Response to BDA Comments

The below letter provides commentary on the Barangaroo Delivery Authority Design Advisors Comments and Design Director comments, as required by the Endorsed Design Excellence Strategy:

Below are summarised comments received from the BDA and the architectural response to those comments.

1 | East Elevation
1 : 300

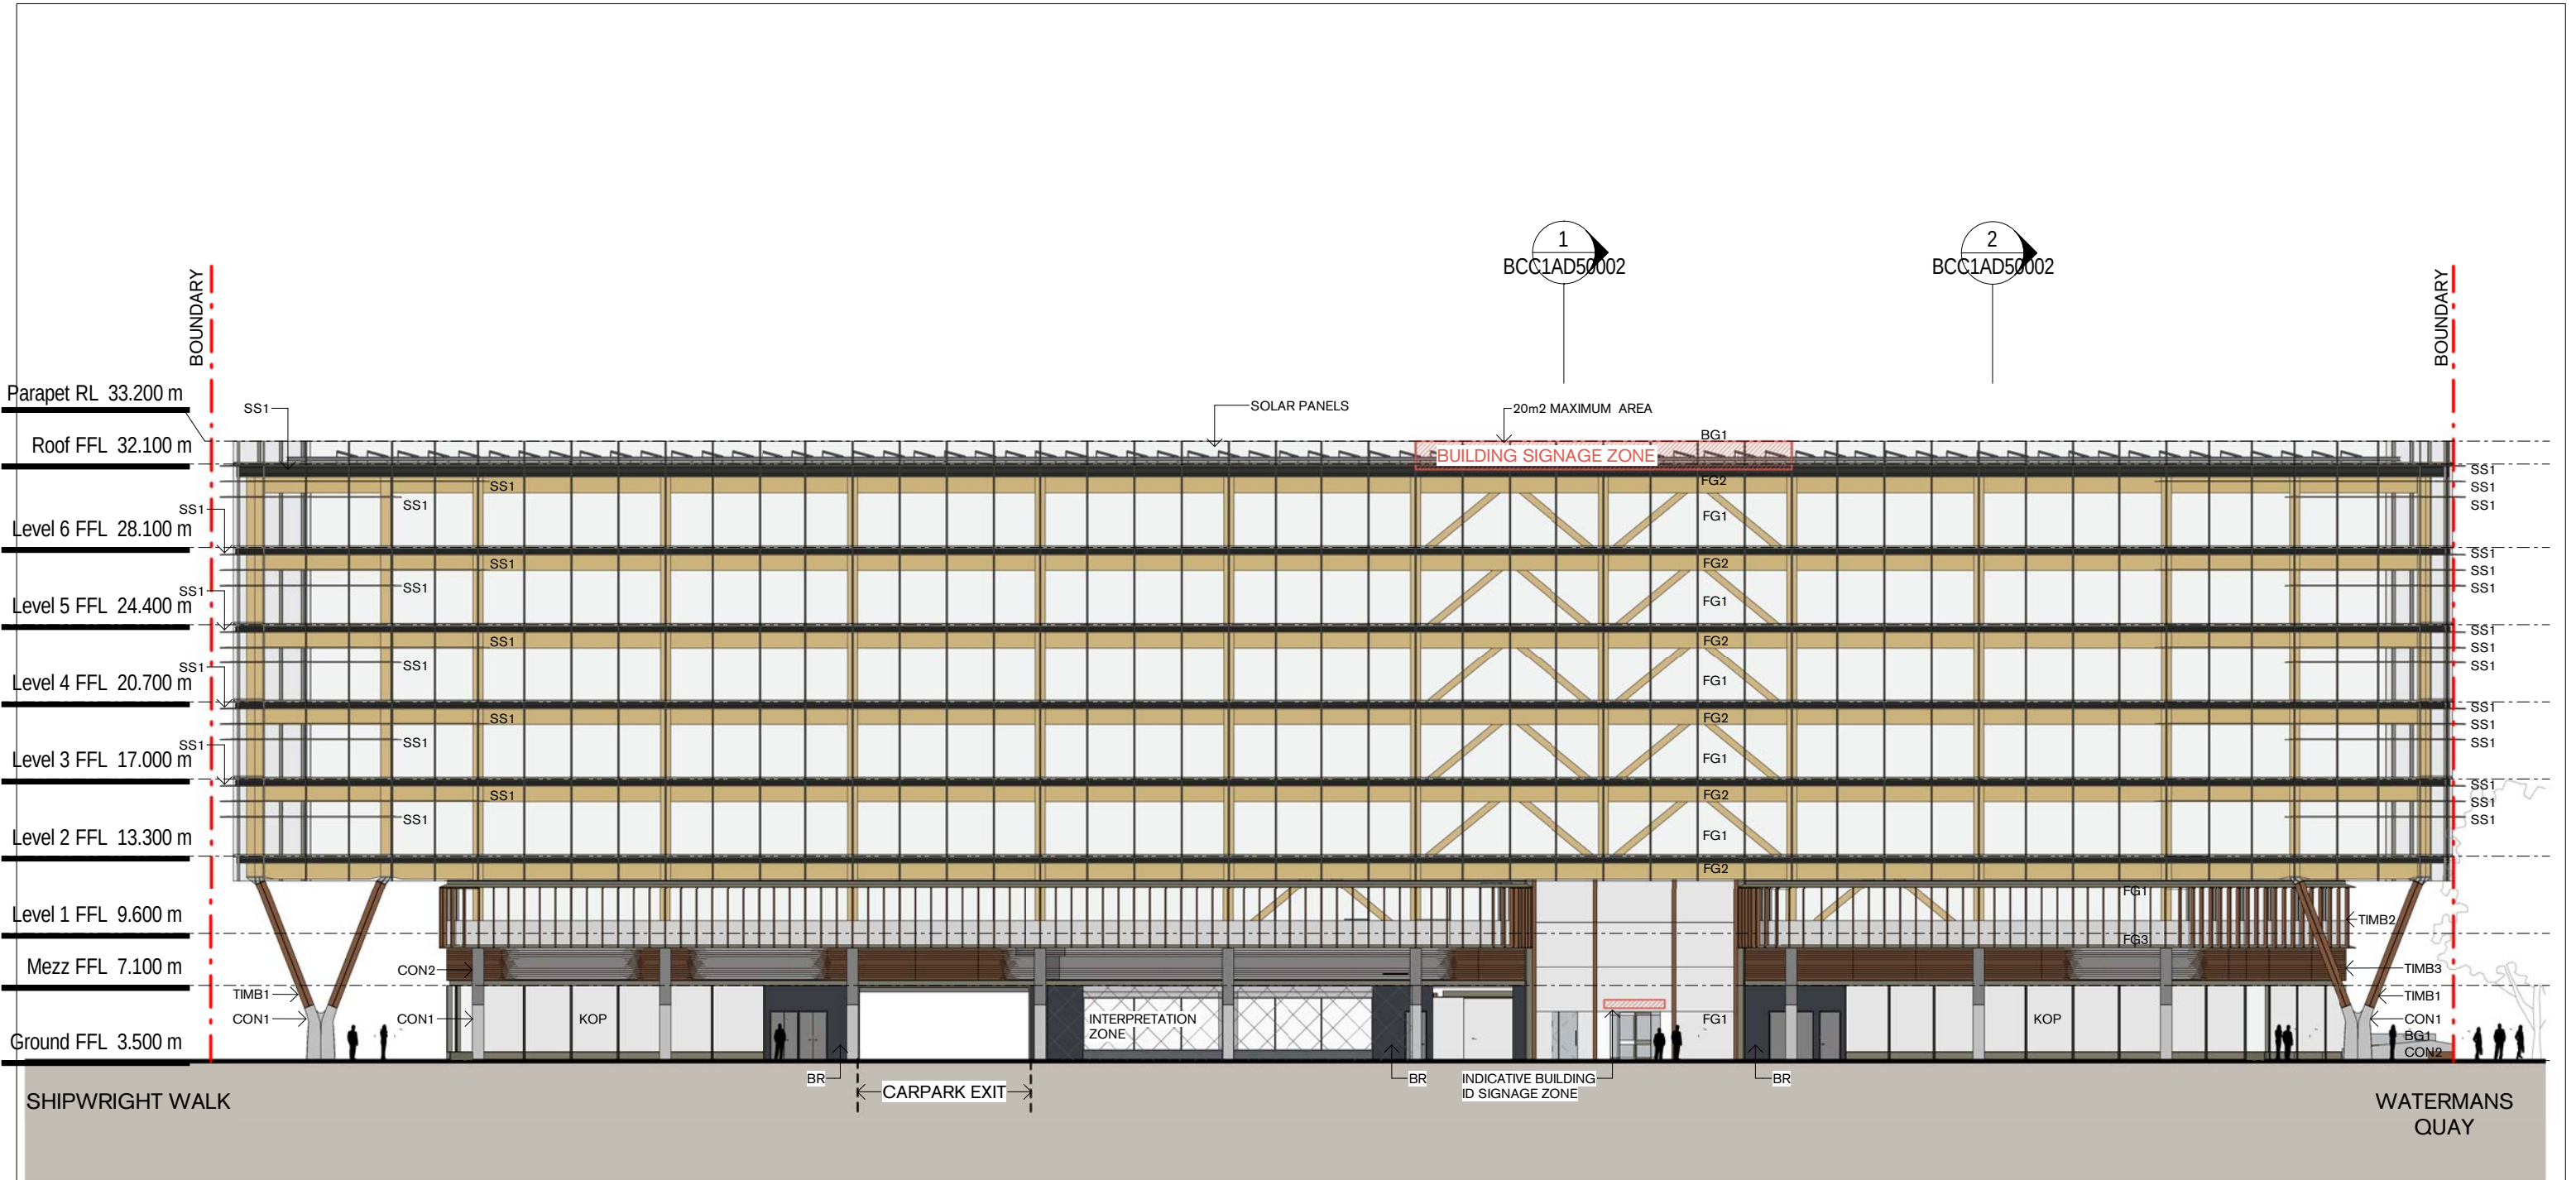
<p>South Undercroft: Clarify the proposal for the outdoor seating area in the south undercroft.</p>	<p>Lendlease have advised that the retail tenancy on the southern end will not be a food and beverage offering and as such will not have any outdoor seating located in the undercroft space, allowing free pedestrian movement across the space.</p>
<p>Consider relocating the east façade building sign to be centred over the commercial entry point.</p>	<p>East elevation amended to consolidate the two proposed buildings signs to one located above the entry.</p>

Indicative Design for Northern Seating Area with Wind Amelioration Elements Shown

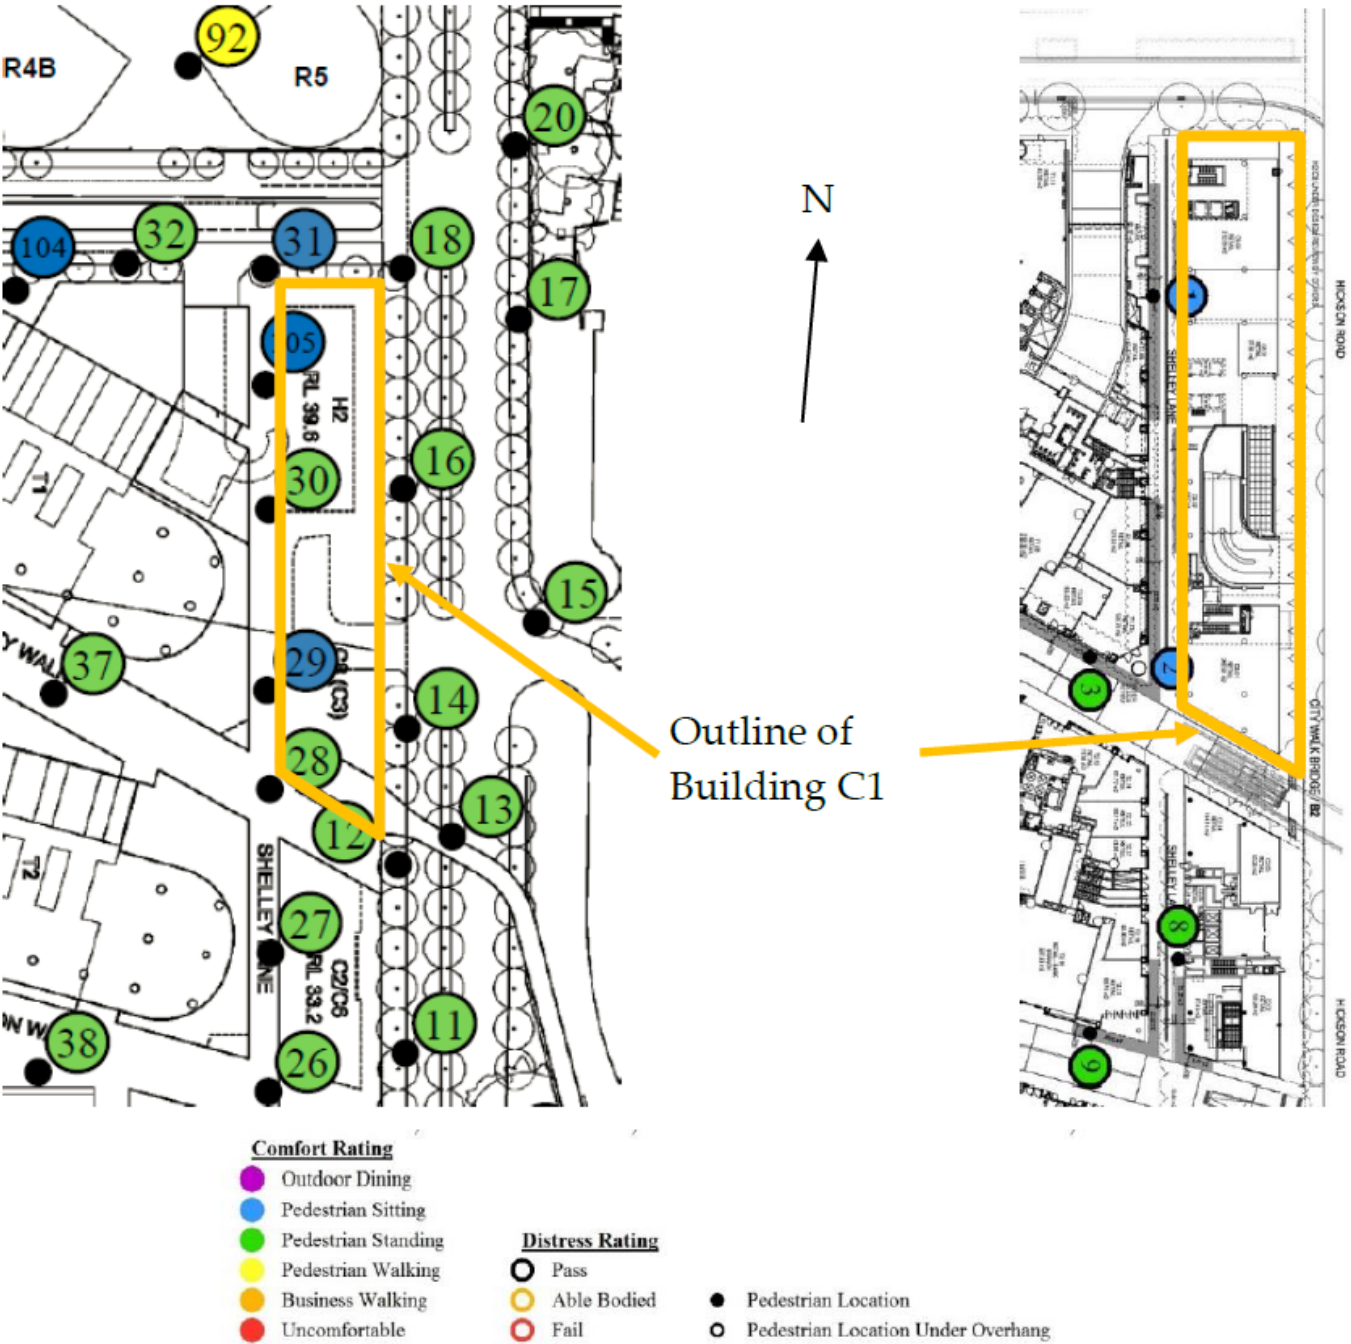
<p>Clarity is required around the intentions for the northern ground floor retail space/s. What are the strategies for shading, seating, access, heating, etc. The design should be developed with the retail team to ensure the built form provides for proposed retail strategies.</p>	<p>Lendlease have advised that the northern retail space will be a food and beverage offering. The outdoor area is considered an extension of the indoor retail space. It is anticipated that the majority of pedestrian movement from/to the colonnade will be through the colonnade and on the footpath north of the C1 site boundary. Shading will be provided via removable umbrellas, and gas bayonets will be provided in the paving to allow for connection to outdoor heaters without the need for refillable gas tanks.</p>
<p>Consider the reflectivity of the façade and solar panels on adjacent buildings to ensure glare is minimised.</p>	<p>The façade and solar panels will be no different than C2. A reflectivity report has been included in the EIS.</p>
